**From:** isobel.hartley@historicengland.org.uk  
**Sent:** 28 March 2025 11:53  
**To:** \_planningadvice  
**Subject:** Historic England advice on Application no(s) H16-0209-25  
**Attachments:** H16-0209-25\_HERef\_L01589581\_L467736.doc

The Sessions House, Sheep Market, Spalding, Lincolnshire, PE11 1BB  
Application No(s):H16-0209-25

### **Arrangements for Handling Heritage Applications Direction 2021**

**Application No. H16-0209-25**

PROJECT TITLE Proposed Removal of Tiered Veiling Gallery	CLIENT Castle Events Ltd, The Sessions House, Sheep Market, Spalding	CHK BY ---	DRAWN BY CLA
DRAWING STAGE Planning	SCALE 1:50 @ A1	STAGE PLN	REV D
SHEET TITLE Plans as Proposed	PROJECT NUMBER PE11-4138	REV D	SHT 003

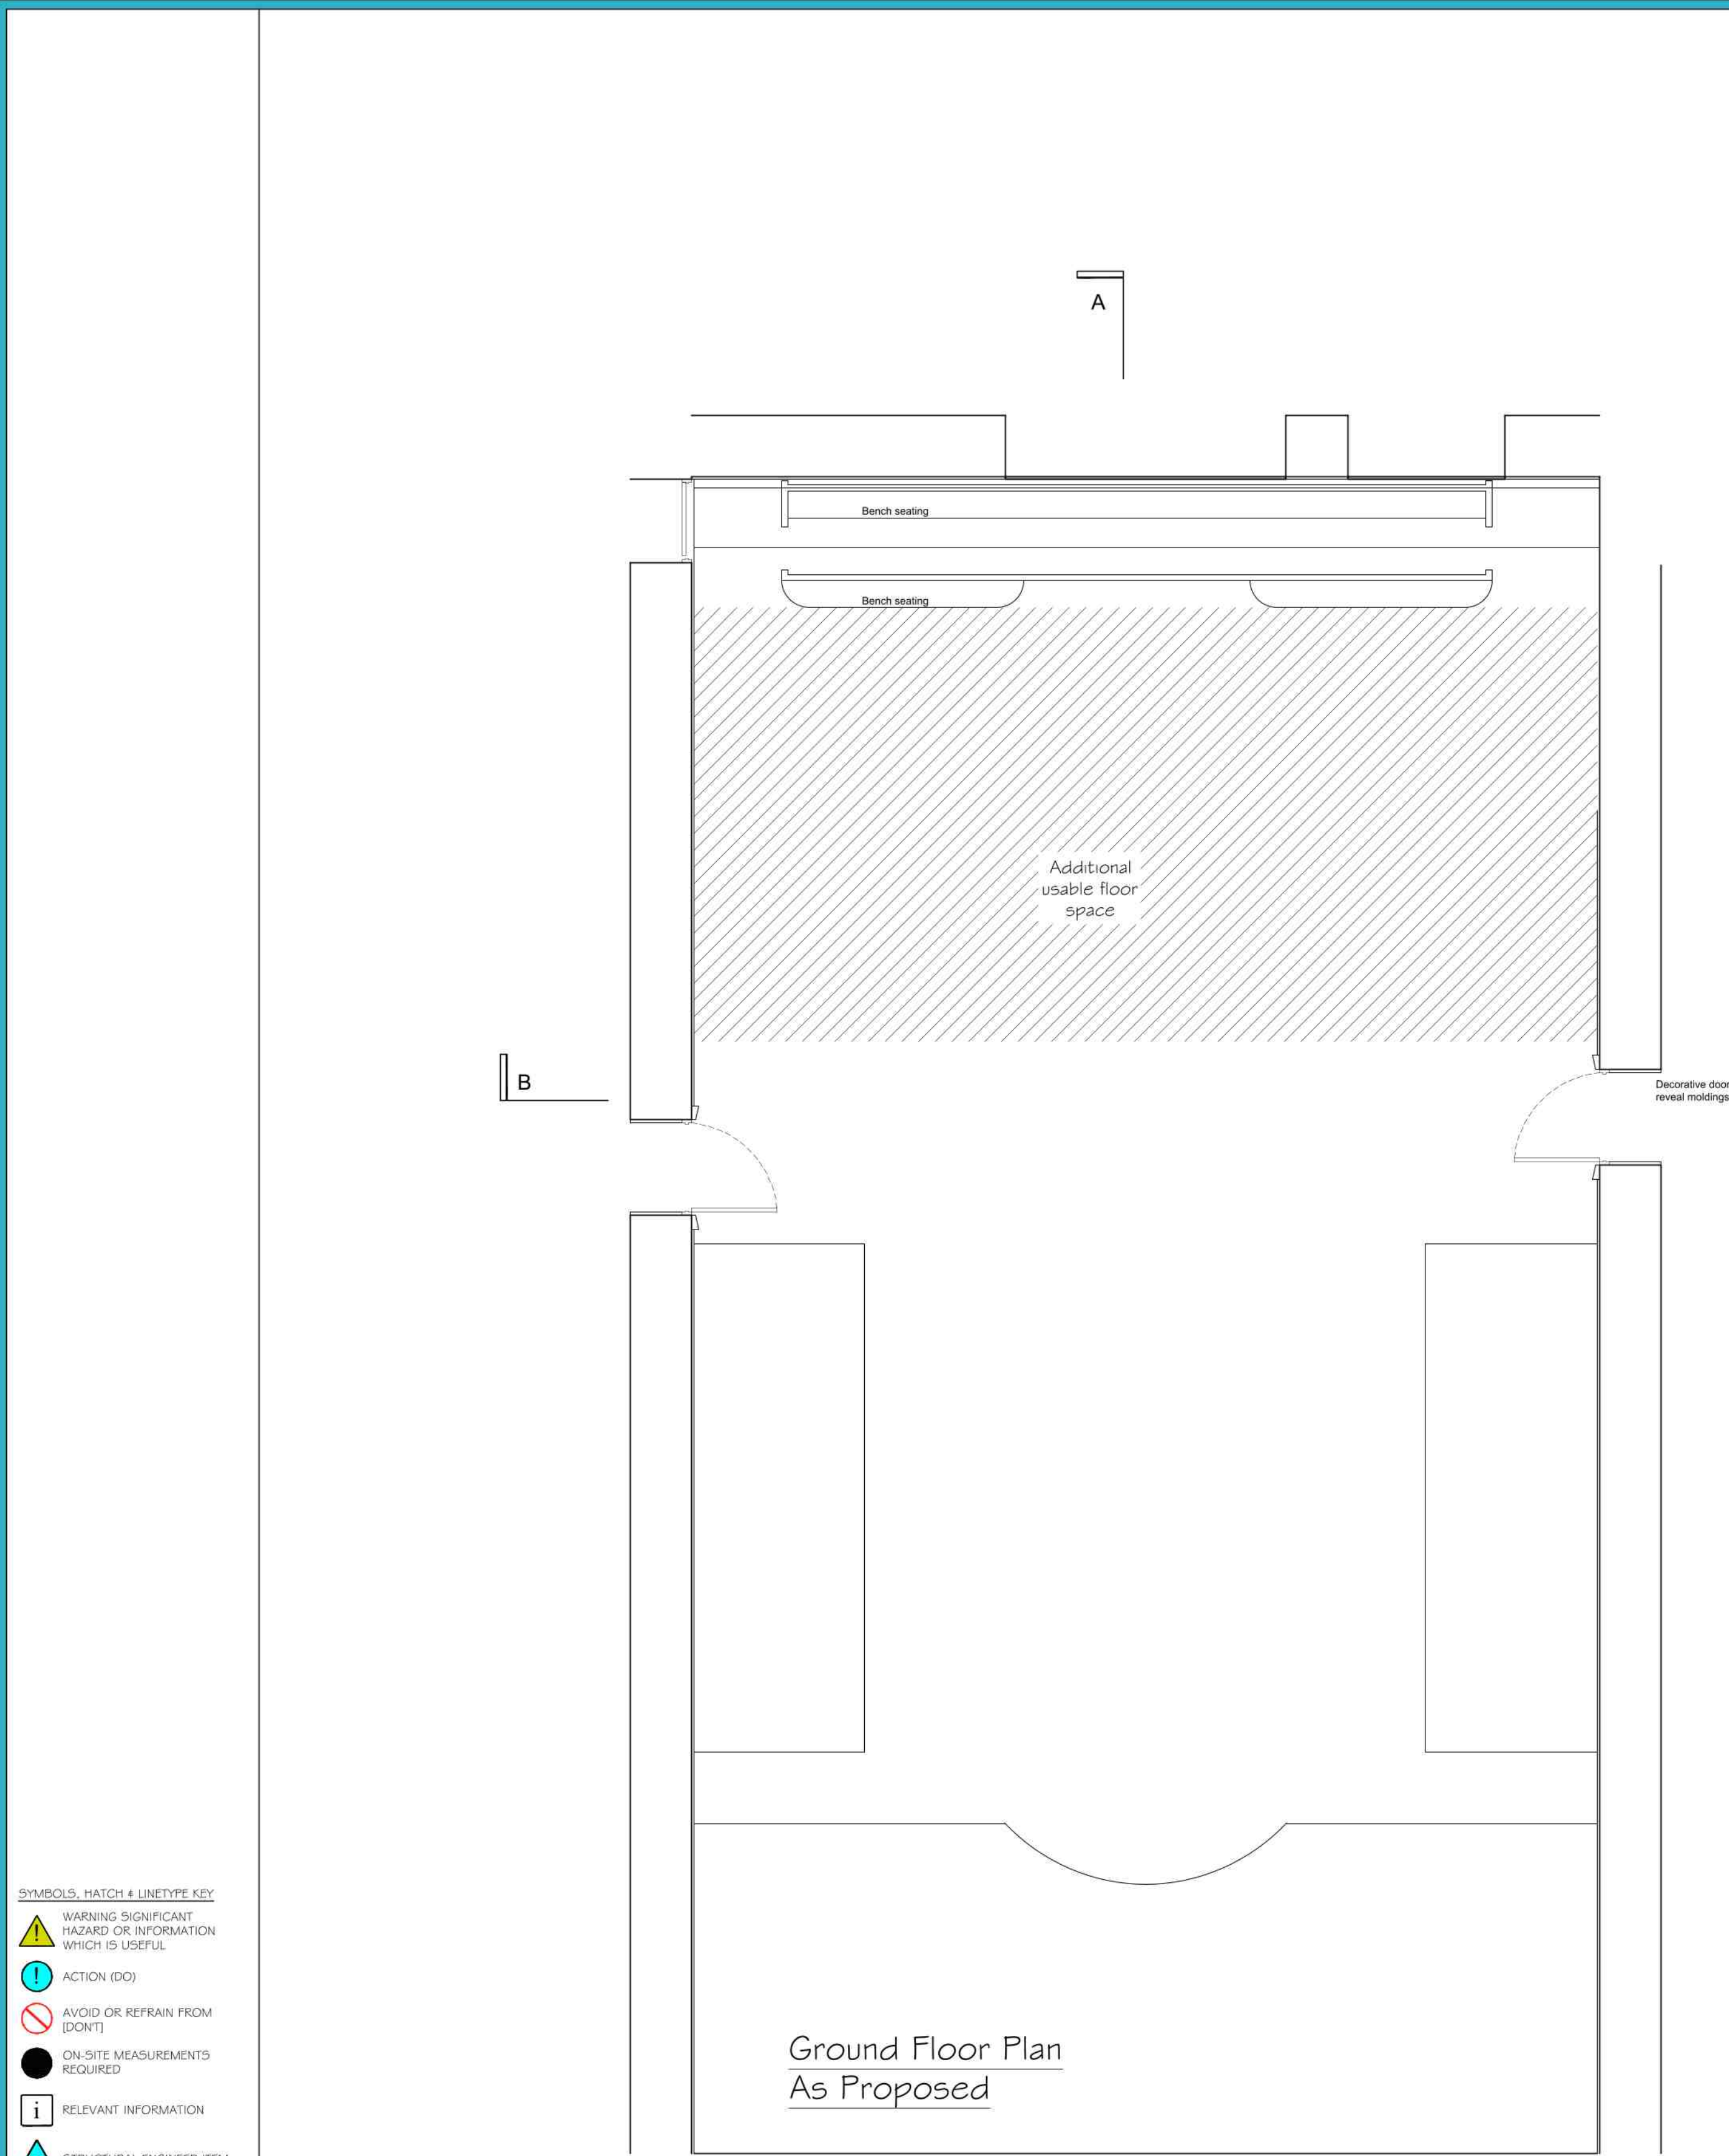
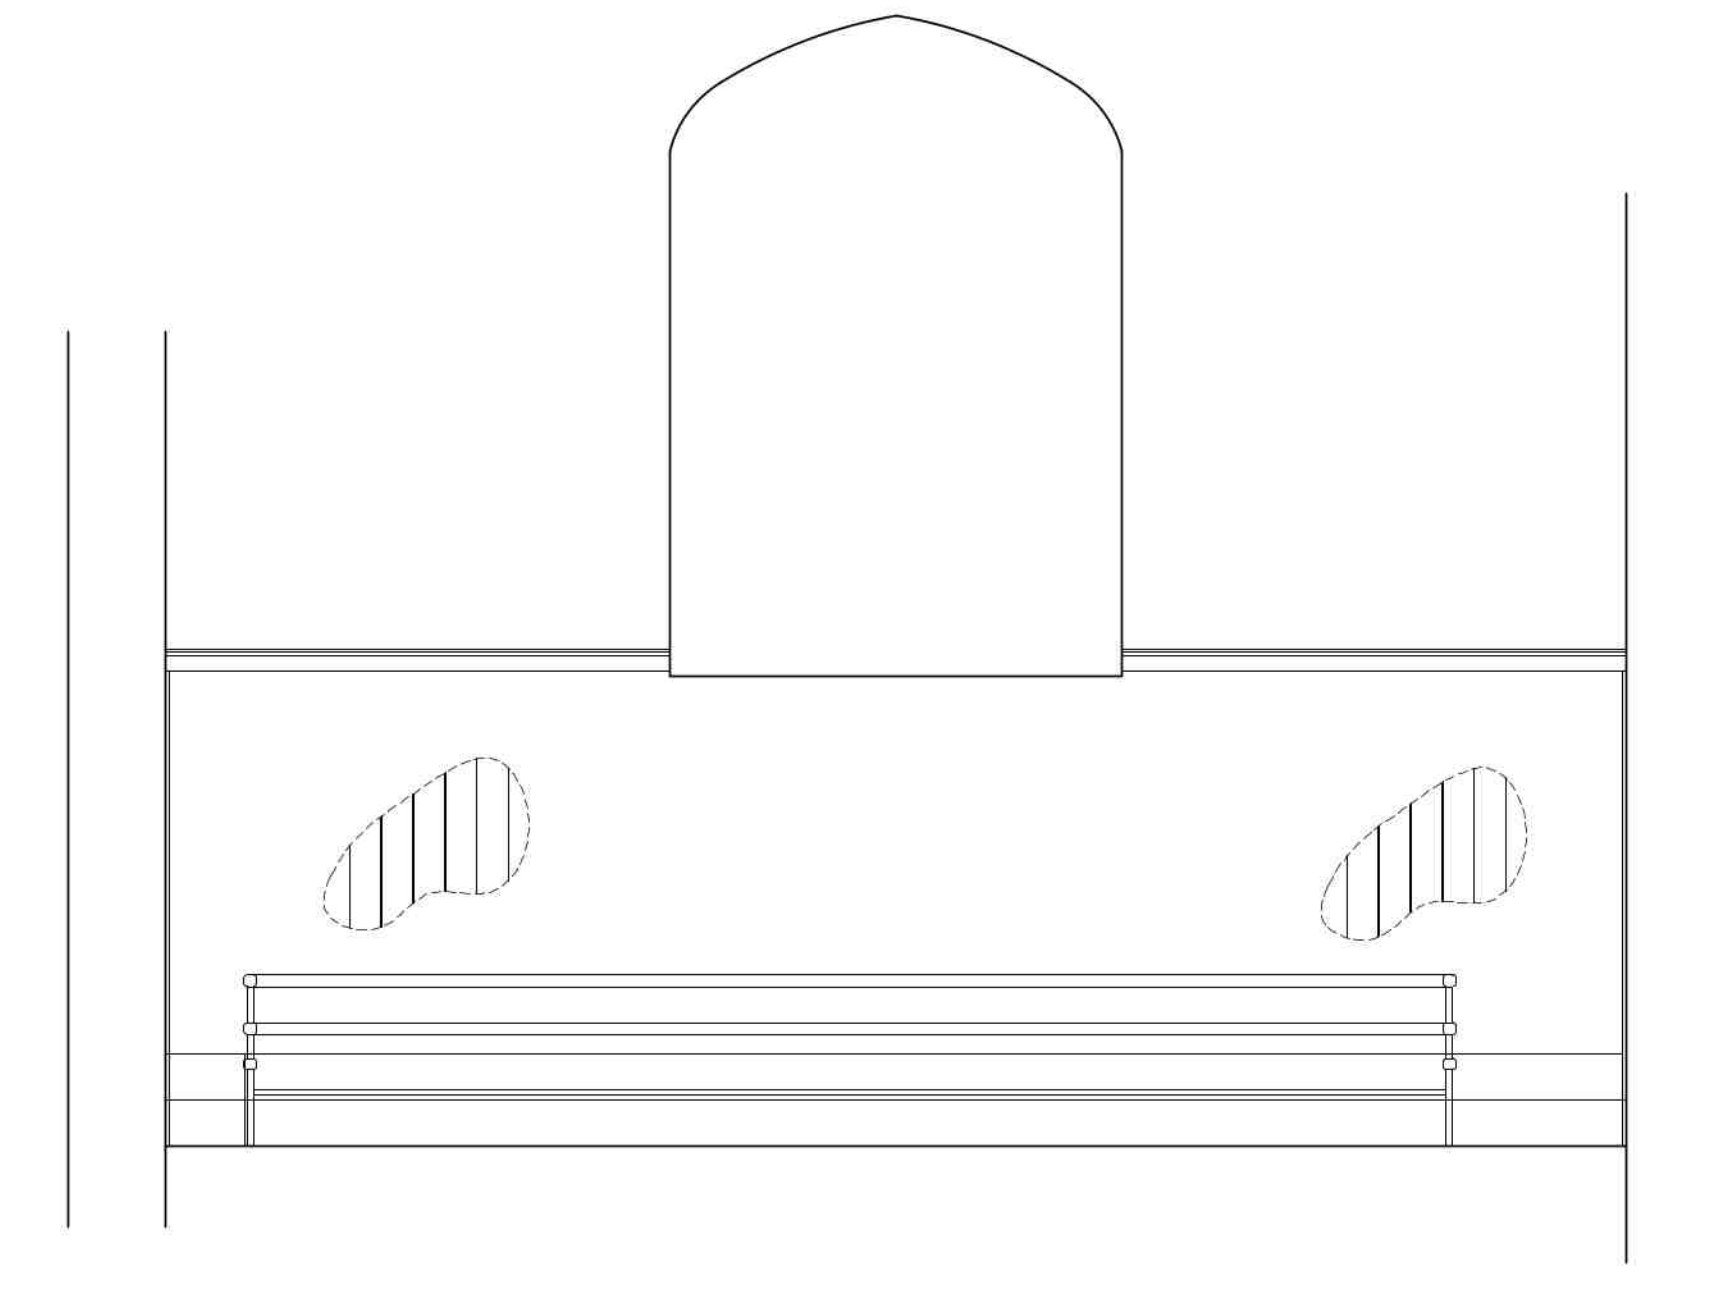
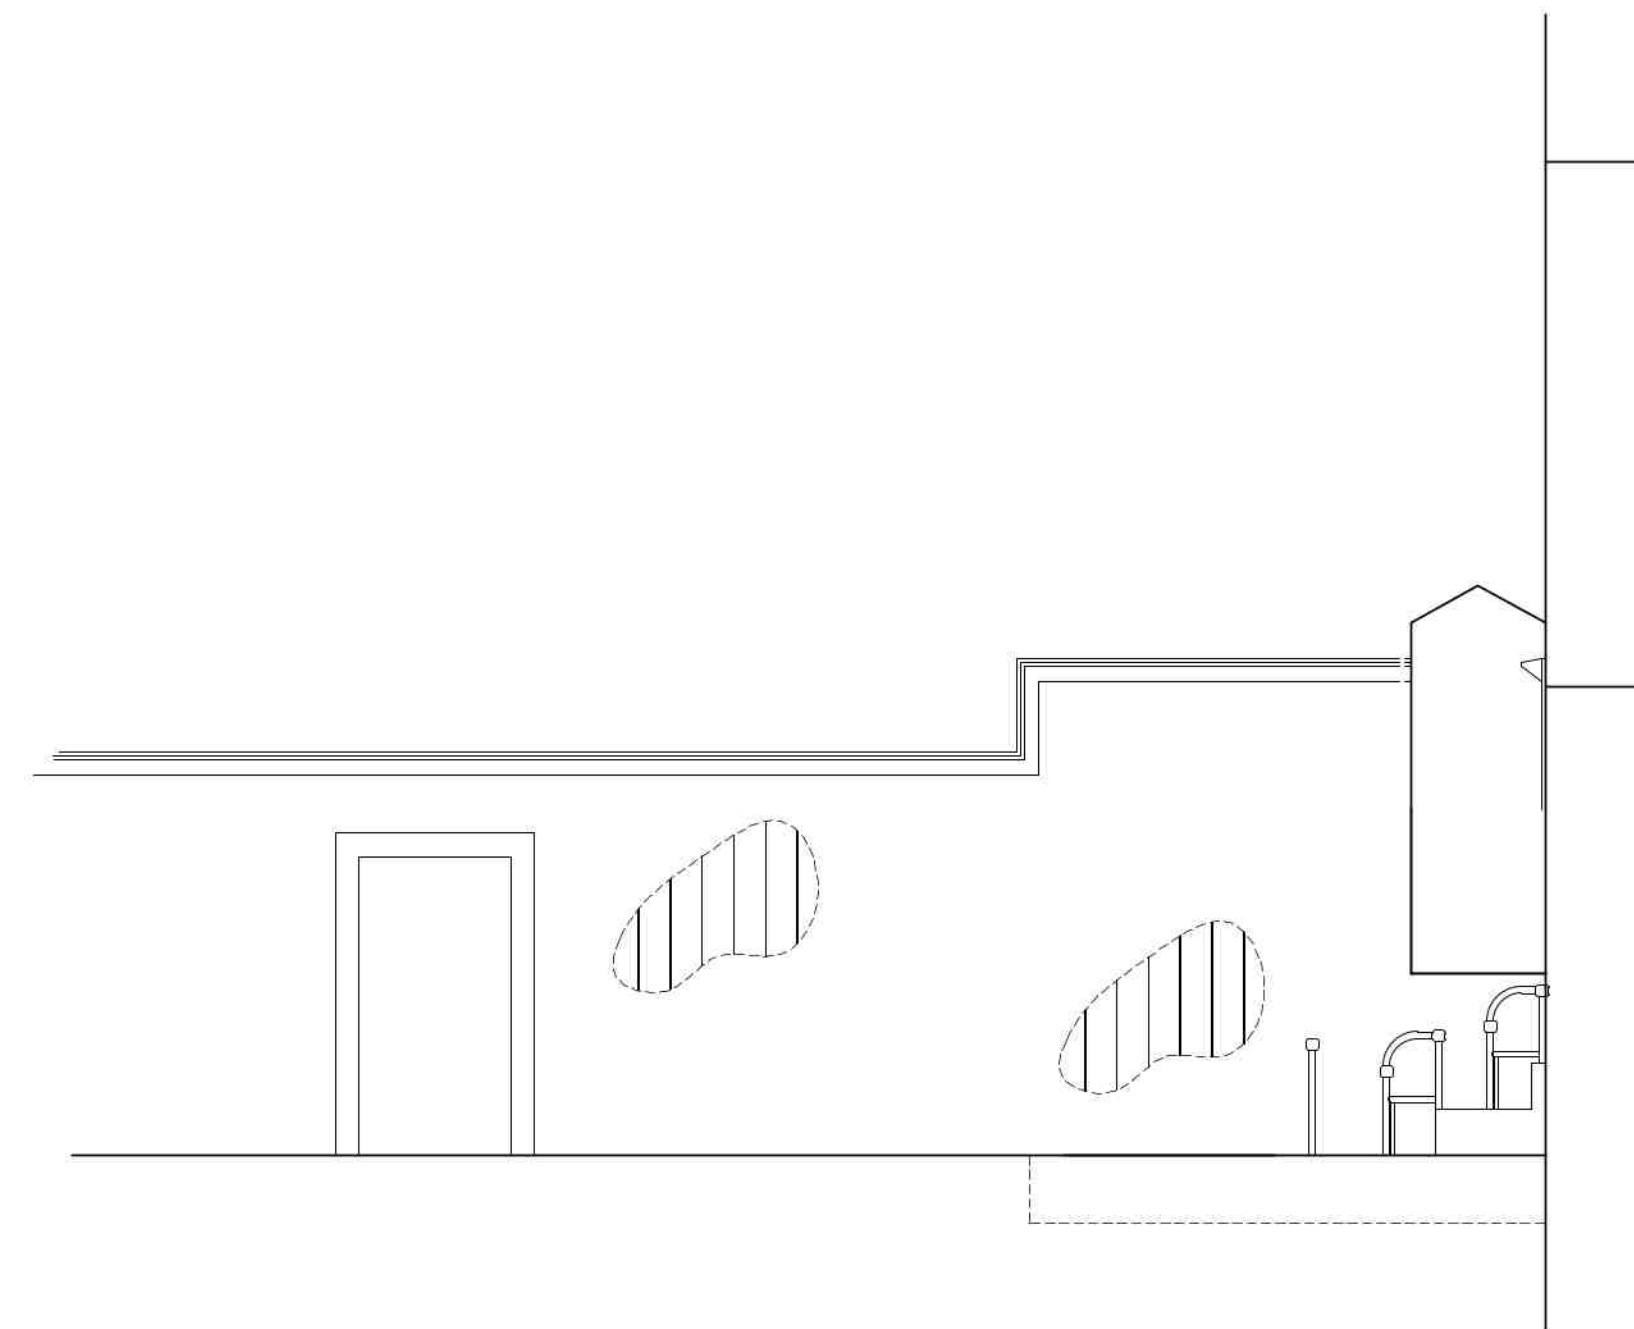
We do not object to the removal of some of the benches within the viewing gallery, however we do have concerns with the removal of all benches as currently proposed.

The benches are intrinsic to understanding the room's previous purpose, therefore the total removal of all benches in the Viewing Gallery would be harmful to the building's overall heritage significance.

We encourage the exploration of other configurations which would include the retention of some of the fixed benches.
